RE: Existing Tank Application # BRES2002-0049

An attempt was made to evaluate your property for the purpose of issuing an existing tank permit. The evaluation could not be completed for one or more of the following reasons.

## Operation Permit

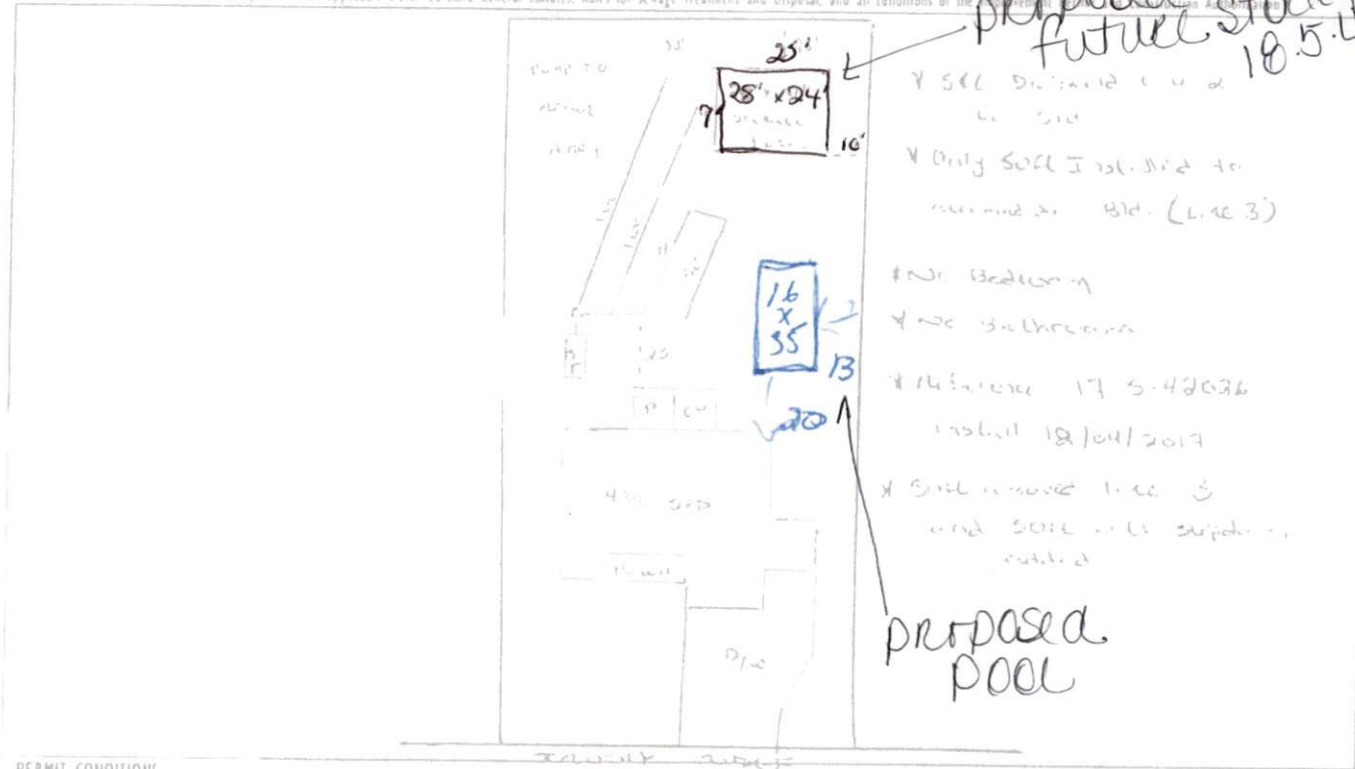
4. **Other – Proposed pool encroaches on 15ft minimum septic system setback. Existing system flagged onsite and homeowner provided options on approvable pool location, size and shape. Homeowner instructed to revise paperwork and reflag pool accordingly for approval.**
